**Consultation Response from Trees Planning,
 KC Trees**
**2019/92940 Land west of, Ashbrow Infant and Nursery School, Ashbrow Road, Ashbrow,
 Huddersfield**
**Erection of 161 residential units including a 50 unit extra care facility (all class C3) and public
 open space**
Date Responded: 07/10/19 Responding Officer: NG
Responding Ref: TPO 04/15

Appendix 1: Site Plan	
Ashbrow Road Huddersfield West Yorkshire HD2 1EX JCA Ref: 13945a/JB	24/07/18
NOT TO SCALE	
1	Stop location/number
SC1	Section location/number
	Transect route
	Trees
	Hedgerow
	Transect 1
	Transect 2
Arboricultural & Forestry Consultants

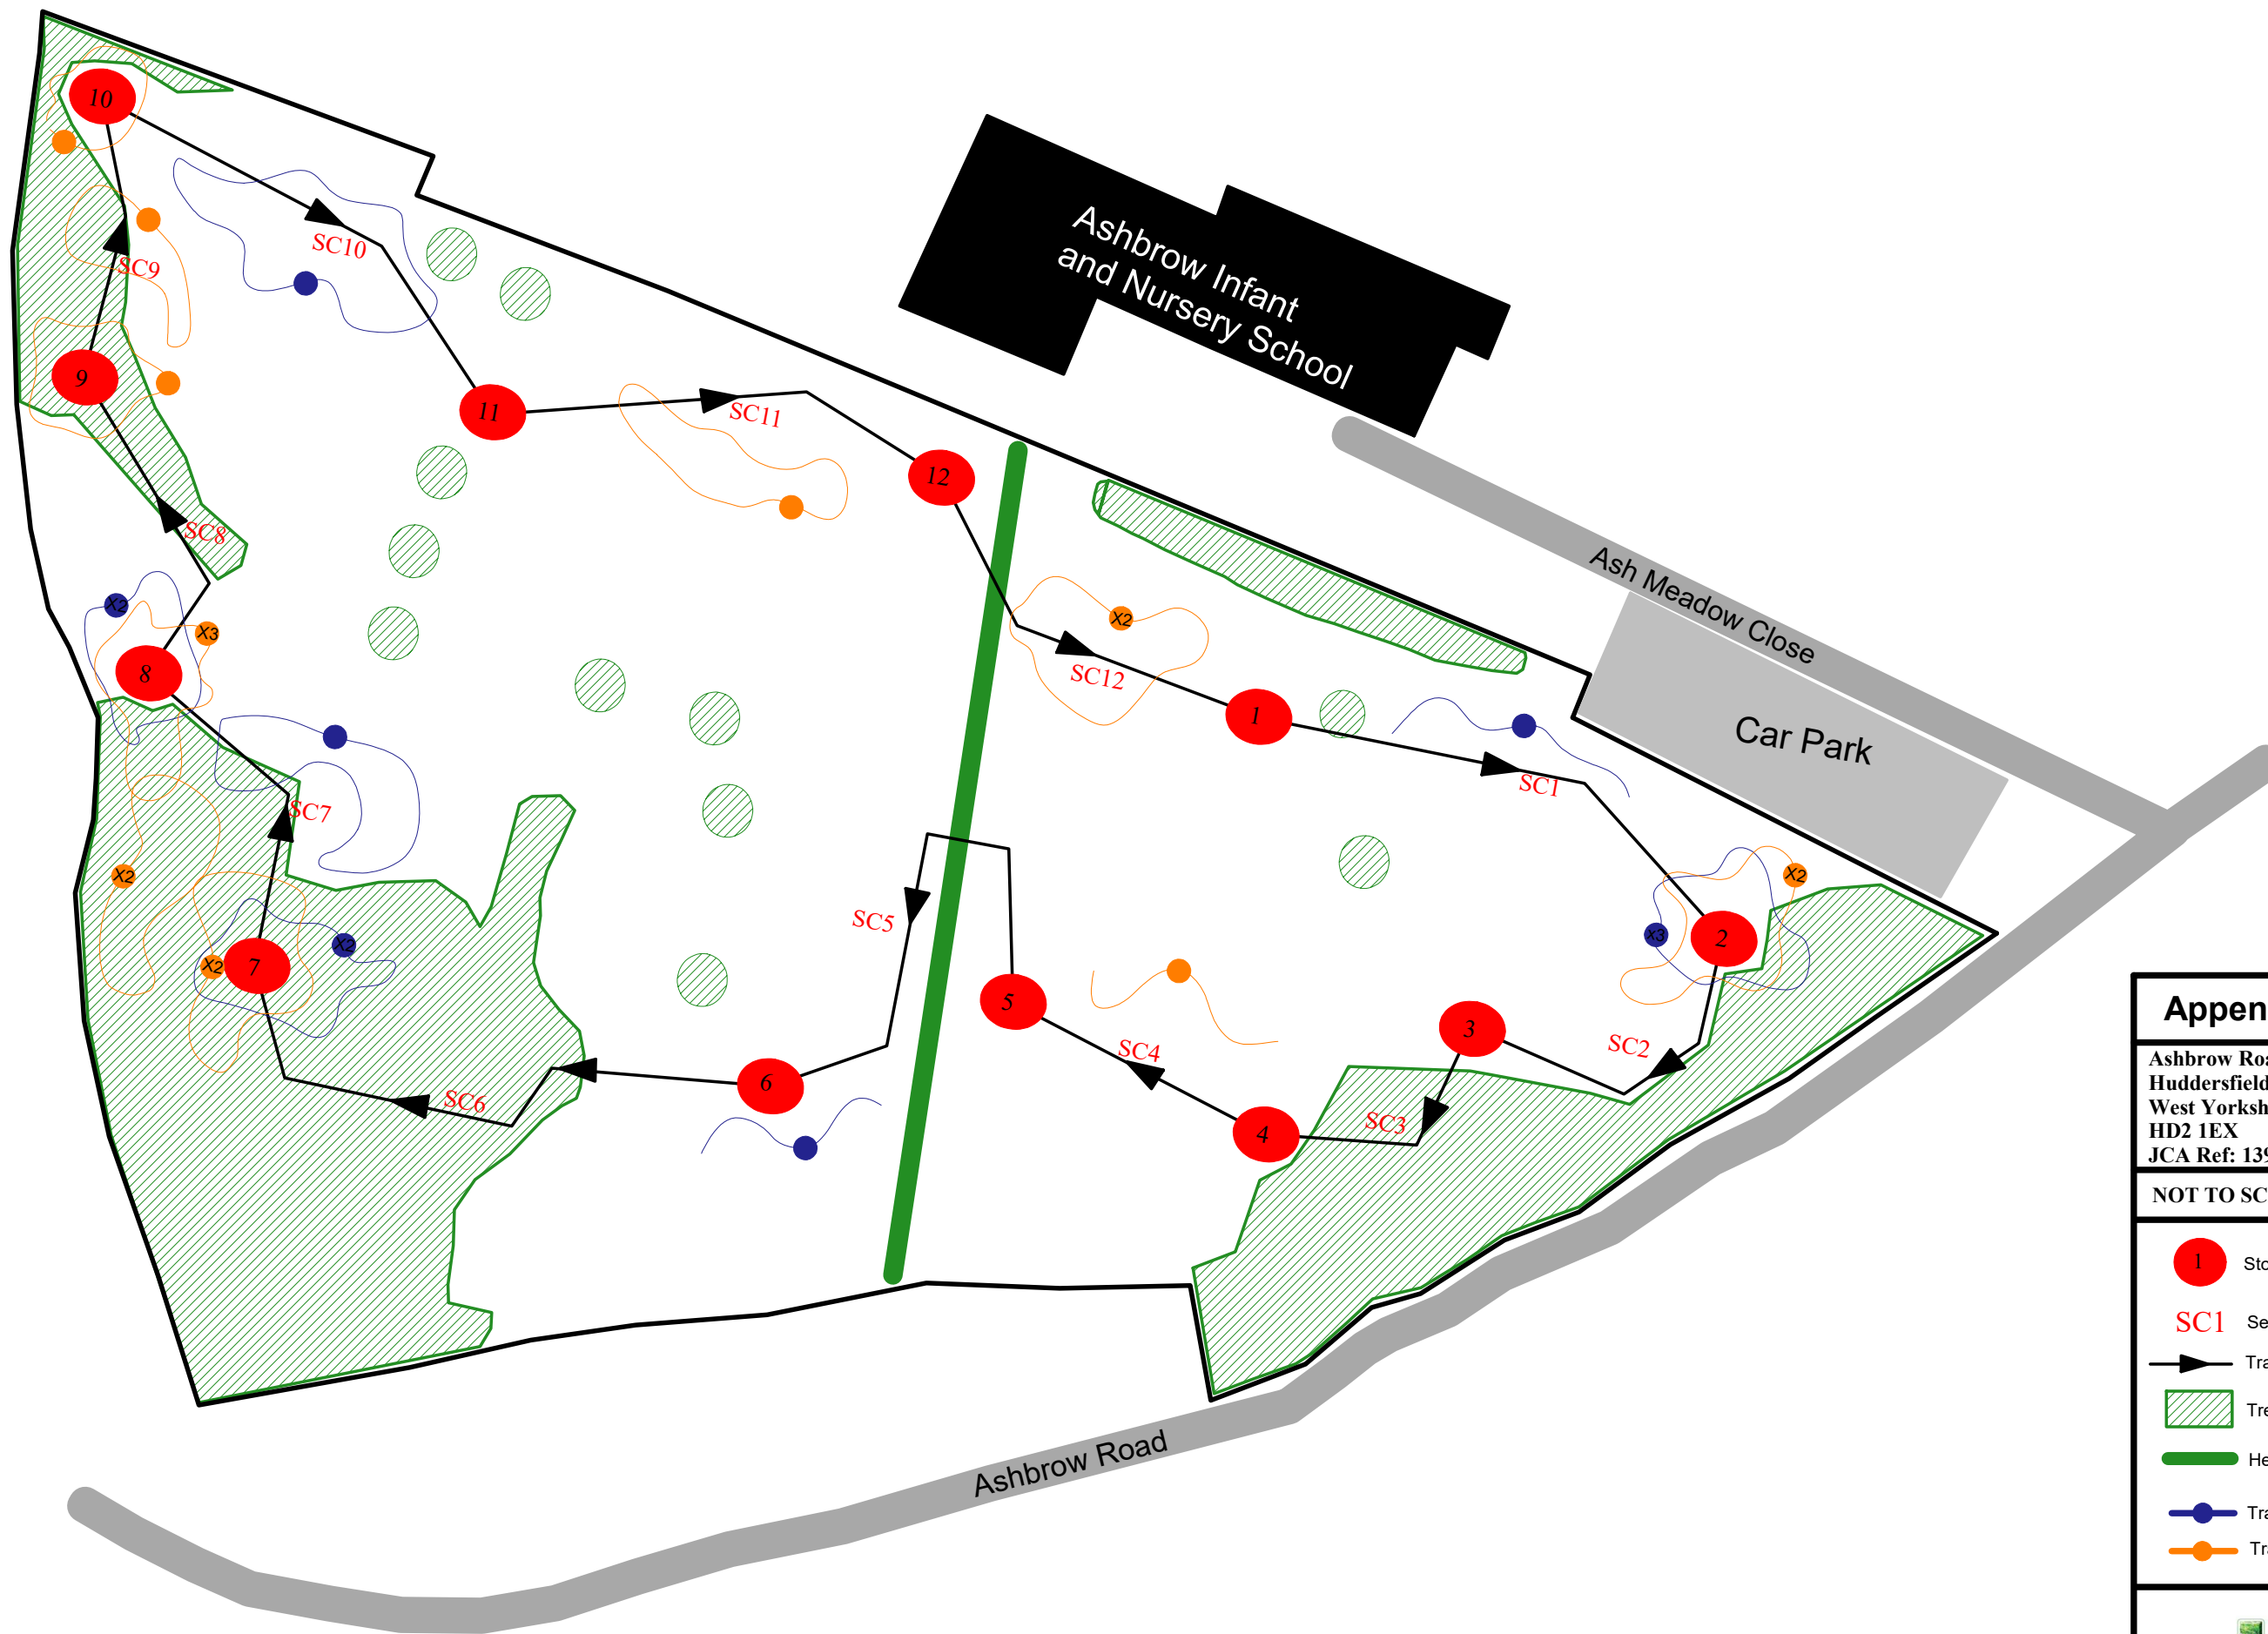
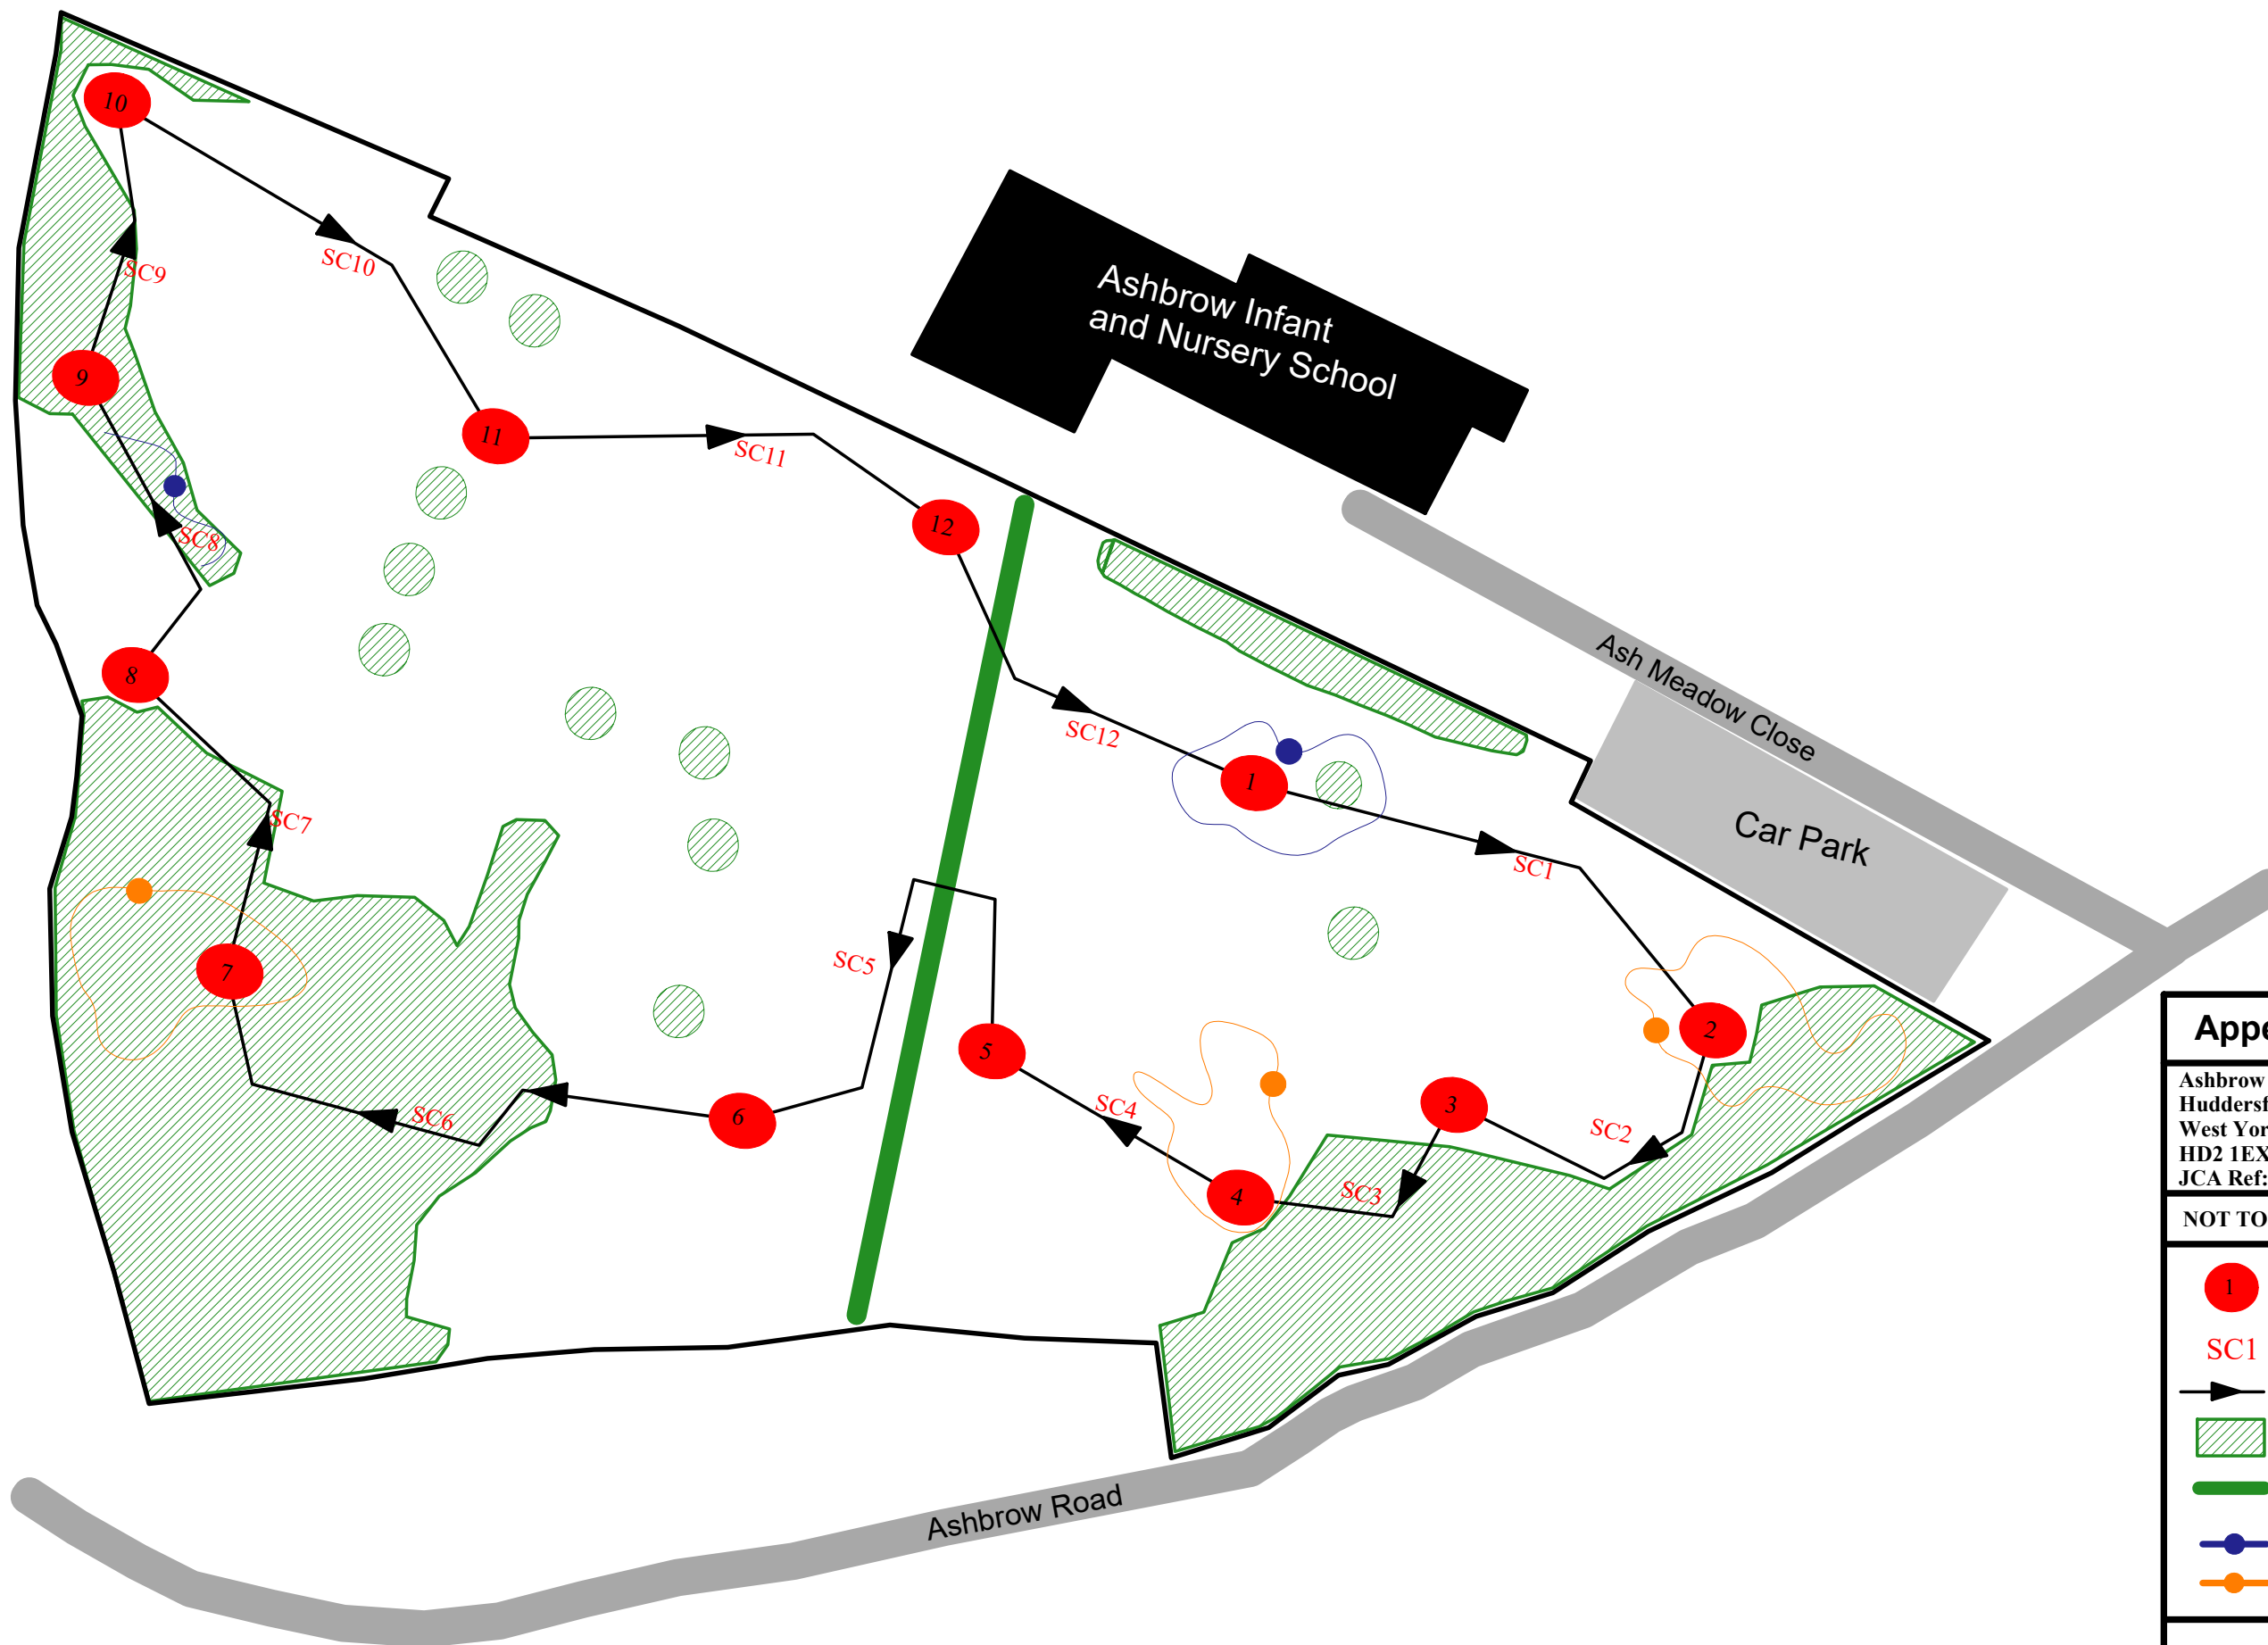
I have no objection to the proposals but am not satisfied with the tree information provided to identify which trees are to be retained and for managing the risk to those retained trees. The Arboricultural Impact Assessment Plan – Appendix F, does not accord with the submitted layout for the site and appears to require more trees than necessary to be removed. The tree removals identified on the Proposed Site Plan, A001 rev Y, are acceptable.

As such I would not want the submitted arboricultural information to be included with the approved documents as they need updating. In order to avoid holding up the application a condition for a site specific Arboricultural Method Statement and Tree Protection Plan, in accordance with BS 5837 could be added to any approval of this proposals.
